Application for a non-material amendment following a grant of planning permission.
 Town and Country Planning Act 1990

Erection of 1No new self build dwelling in lieu of: converting the existing agricultural barn under existing permission (DC/21/03553) and constructing new barn under existing permission (DC/21/03568) .(re submission of withdrawn application DC/21/01817).

DC/21/05455

Change to the position and the dimension of the openings (window /door).

Project:	Fellows Farm	Job:	2212
Title:	Proposed Elevations		
Scale @A1: 1:50	Number:	1301	Rev: A
Scale @A3: 1:100

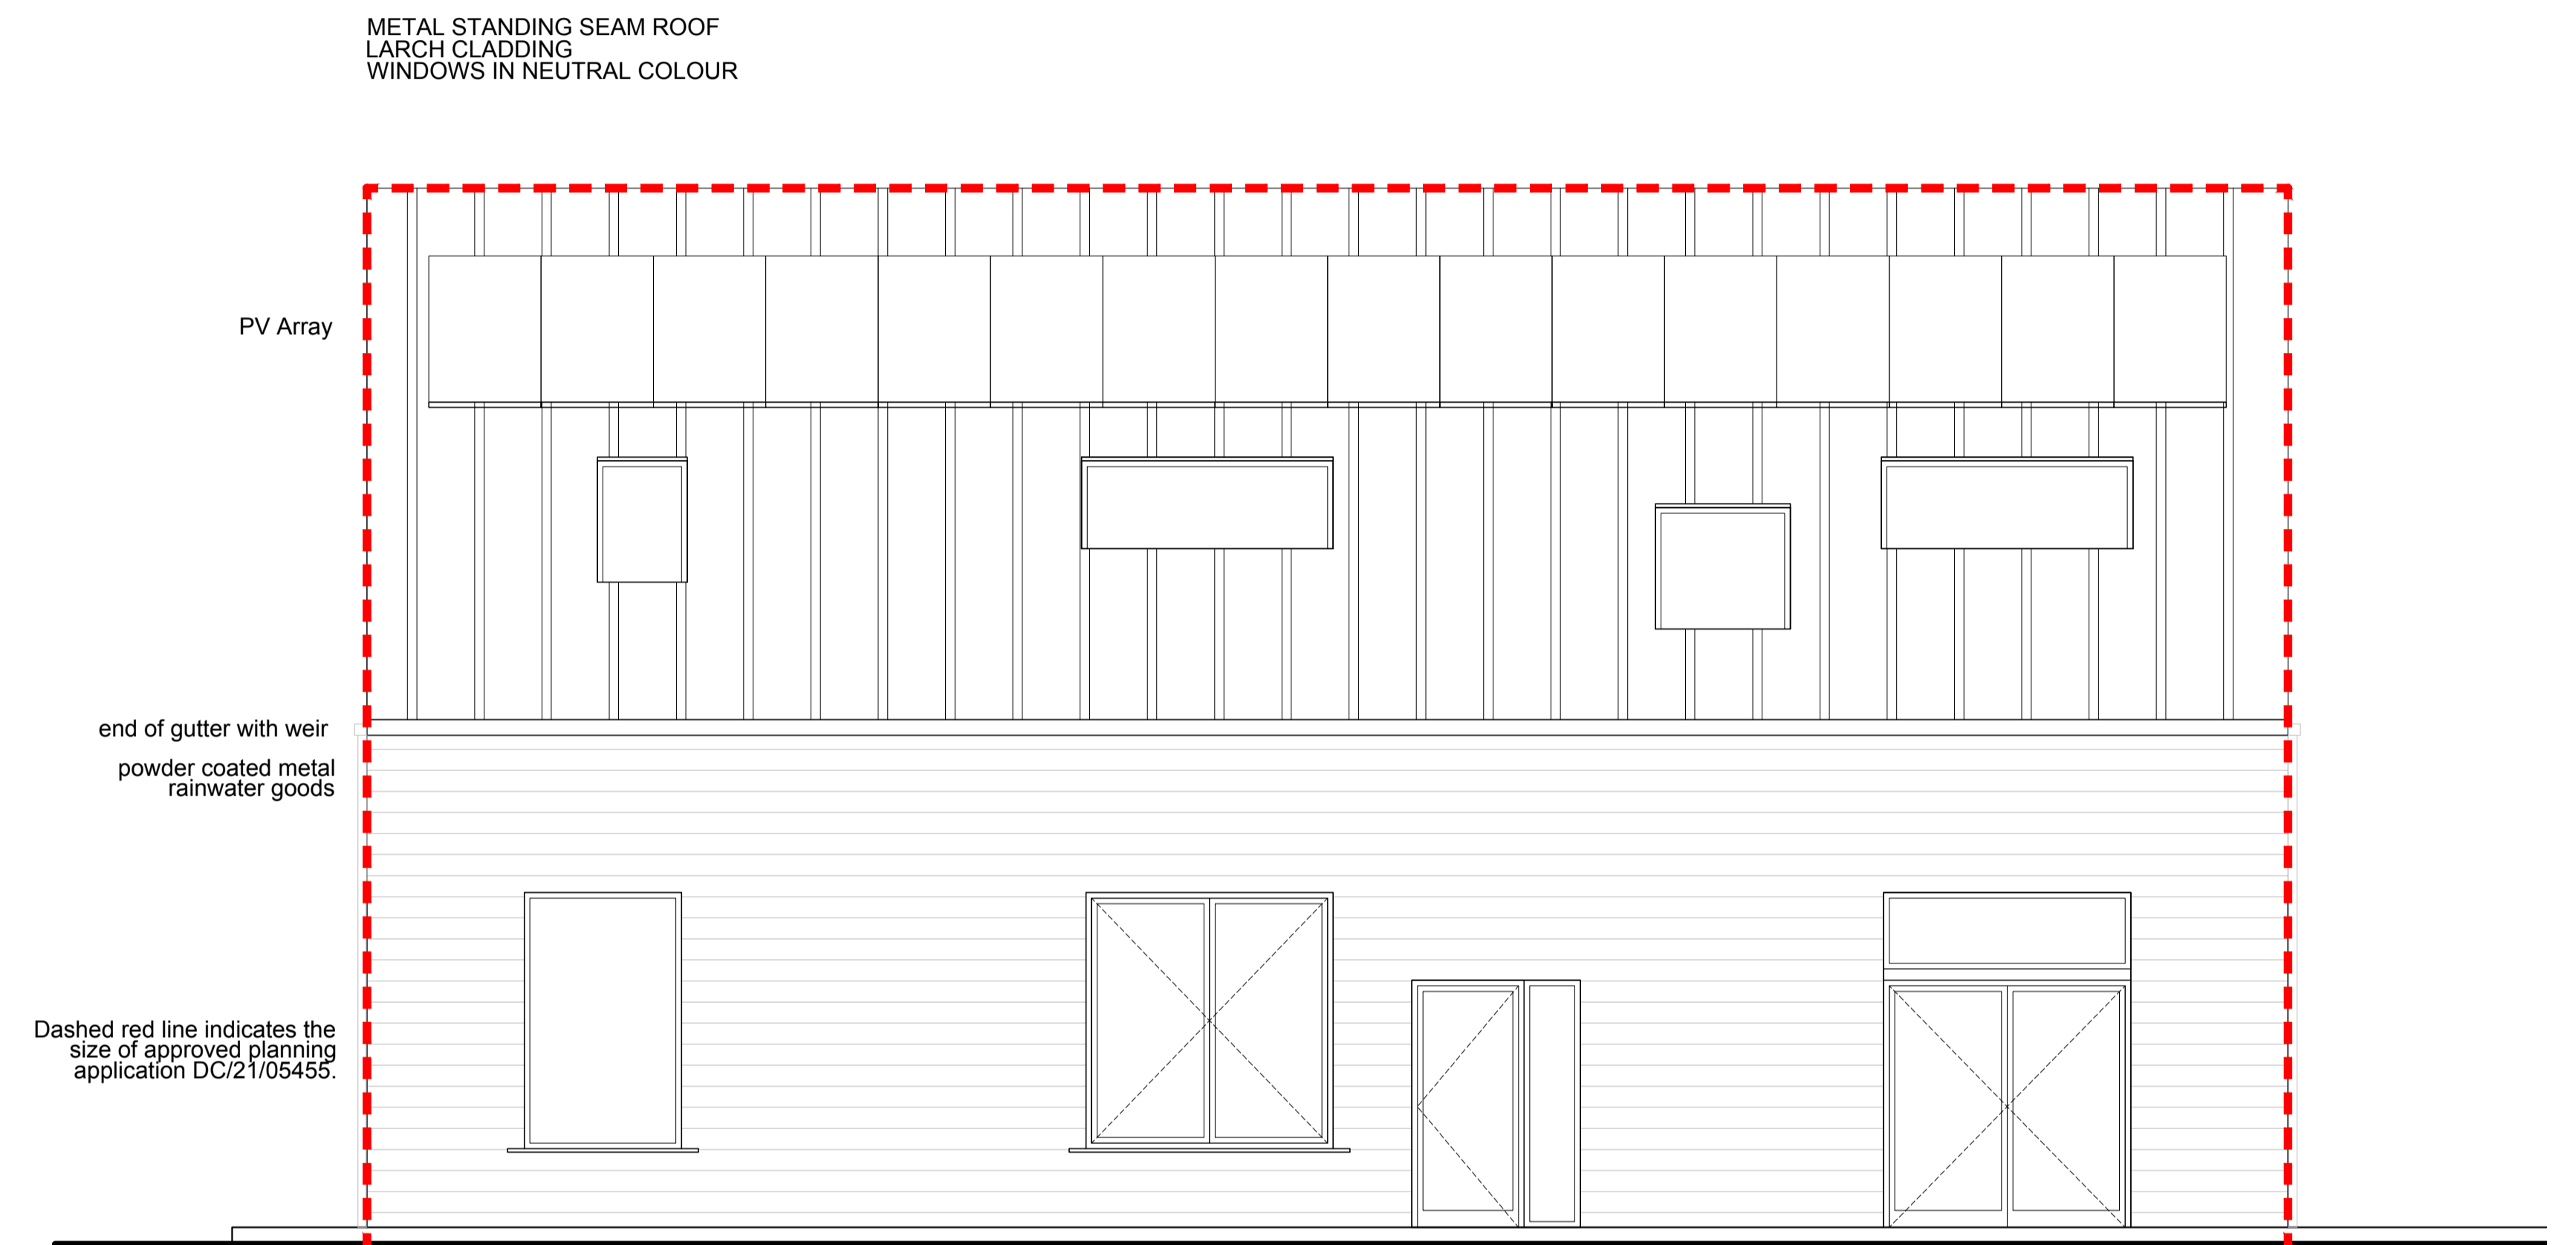
No changes to the dwellings external materials, position, footprint, eaves, roof pitch or ridge height.

The position of the openings has been changed to reflect updates to the internal layout.
